Re: Status of Improvement Permit Application #08-5-19838
Persimmon Hill Lt 67

An attempt was made to evaluate your property for the purpose of issuing an Improvement Permit. The evaluation could not be completed for one or more of the following reasons.

Joe West, R. S.
Environmental Health Specialist
Harnett County Department of Public Health

DB BUILDERS, LLC.
THE CLAREDON WITH SUNROOM
LOT # 67 PERSIMMON HILL
SCALE: 1"=40'

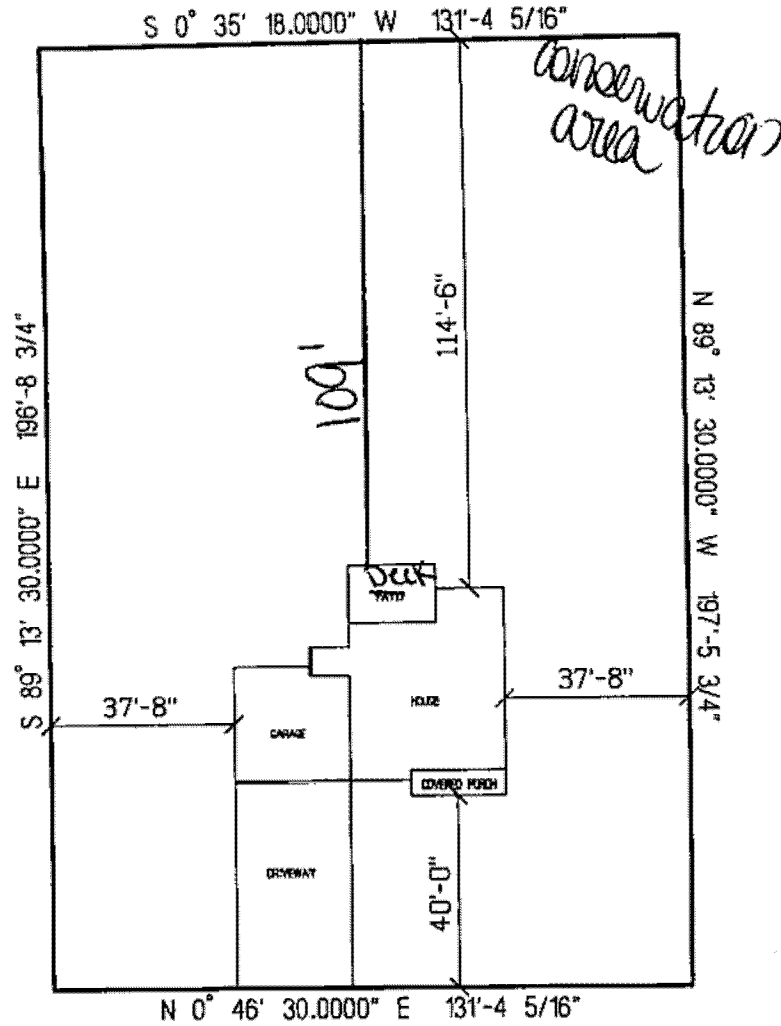
6. **Other – Please move house and drive as shown on attached sheet. Submit new plot plan to Central Permitting.**
